Memorandum

Date: November 8, 2013

Re: Design Review 133 York Street
R6 Design Standards

1
A-202
NORTH ELEVATION
SCALE: 1/4"=1'-0"

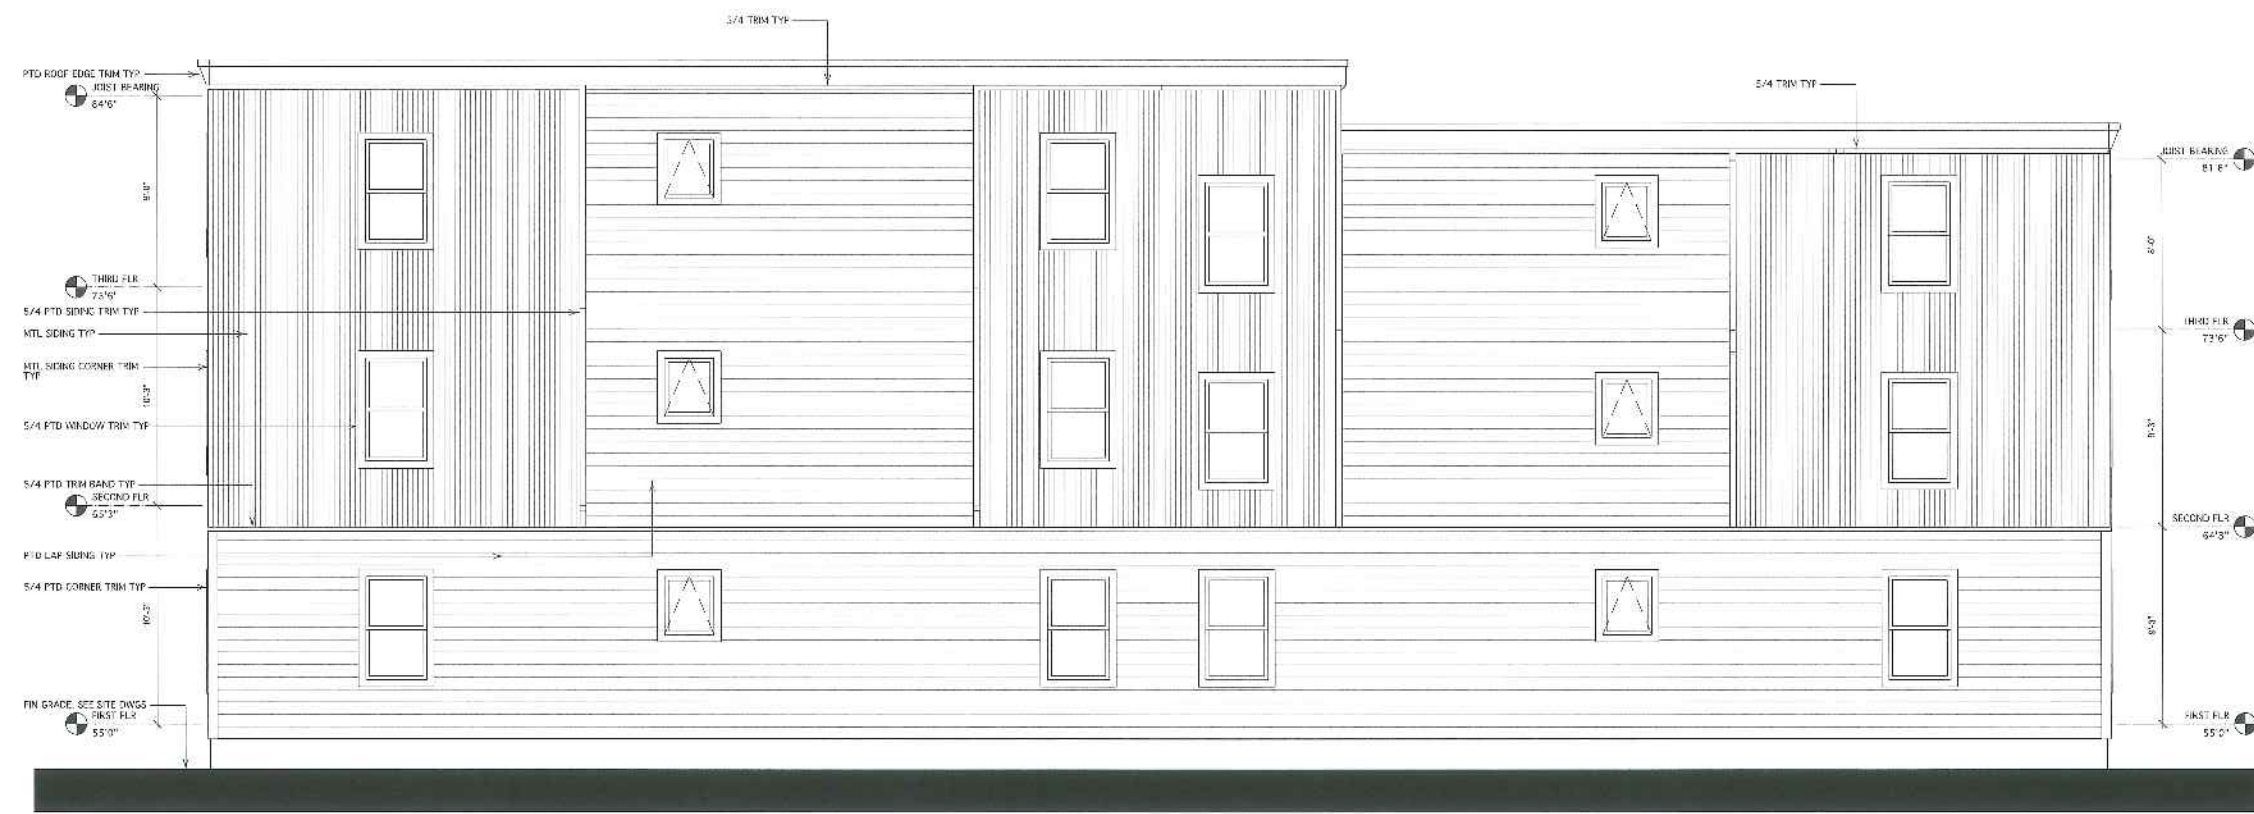
3. The architects submitted revised elevation treatments as part of the October 1, 2013 submission. Staff welcomed the improvements to the front door area but considered that the rear elevation was still unresolved, with little articulation and no obvious design aesthetic. The roof cornice at the rear was suggested as an aspect that could be improved, along with less blue cladding and more/larger windows. A revised elevation was submitted on October 4, 2013 that included more windows, less blue cladding and with the cornice at the rear to match the cornice round the rest of the building. This remains as the final submission for consideration at the hearing.

5. The proposed design should also address the Principle F re “Articulation” (extracted below) and the rear elevation remains weak in relation to this standard. Staff remain disappointed in the rear elevation treatment. It is more balanced with the addition of windows and benefits from the larger cornice treatment. However, it

still lacks in articulation and interest. The applicant has explored relatively minor cladding revisions and these do not fully address the Principle F regarding “Articulation”.
